**RE: PA 08-0212,
Proposed Modification to the New Berrima Clay/Shale Quarry**

I am writing to express my concerns regarding the relocation of the New Berrima Clay/Shale Quarry.

Re: Proposed Modification to the New Berrima Clay/Shale Quarry

Figure B

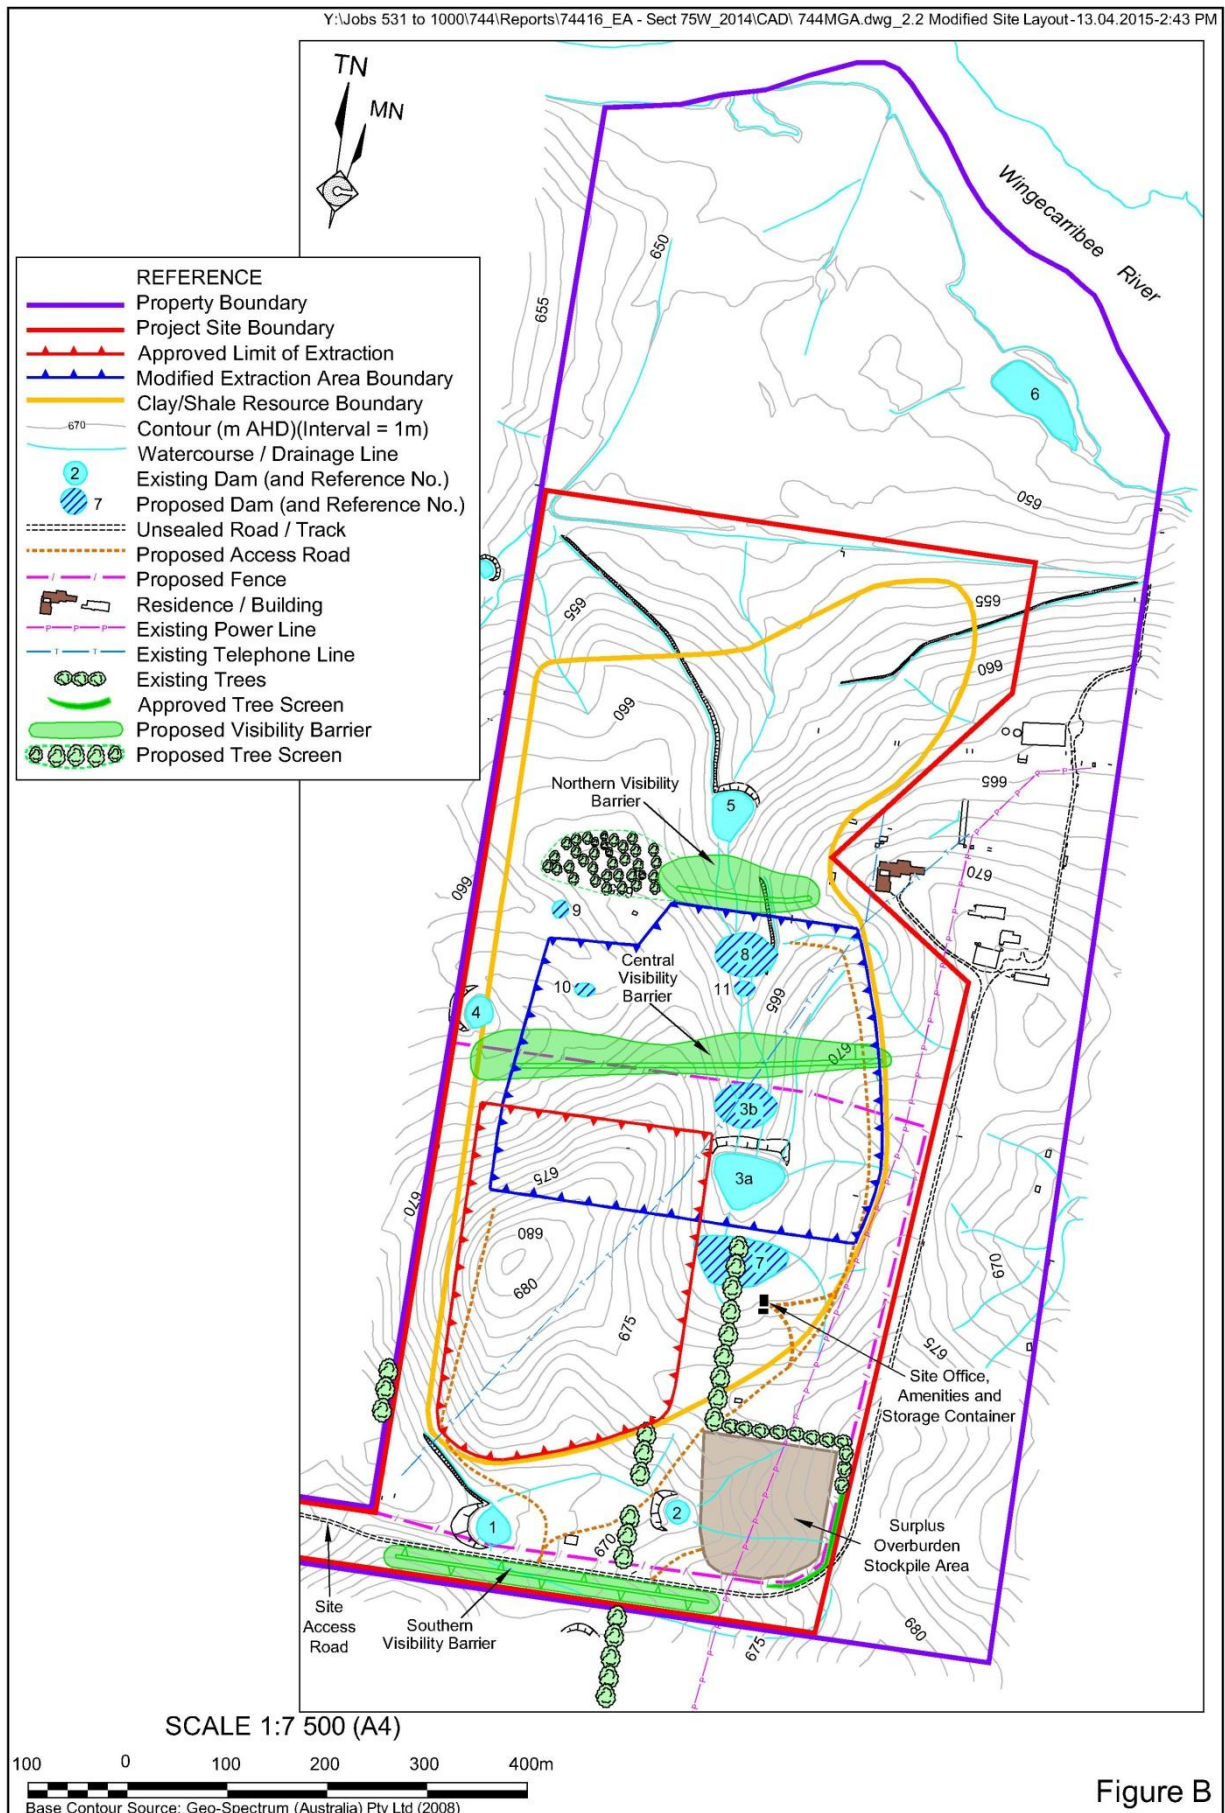
- a) It places the pit considerably closer to the river and our boundary thereby increasing the noise pollution
- b) The increased size of the pit - approx 30% - has a huge impact on the views from our property
- c) The "visibility barrier" would have to be very high as a result of the relocation and I doubt that whether a barrier could and would be constructed which would block the view of the pit from our house and of our neighbours.
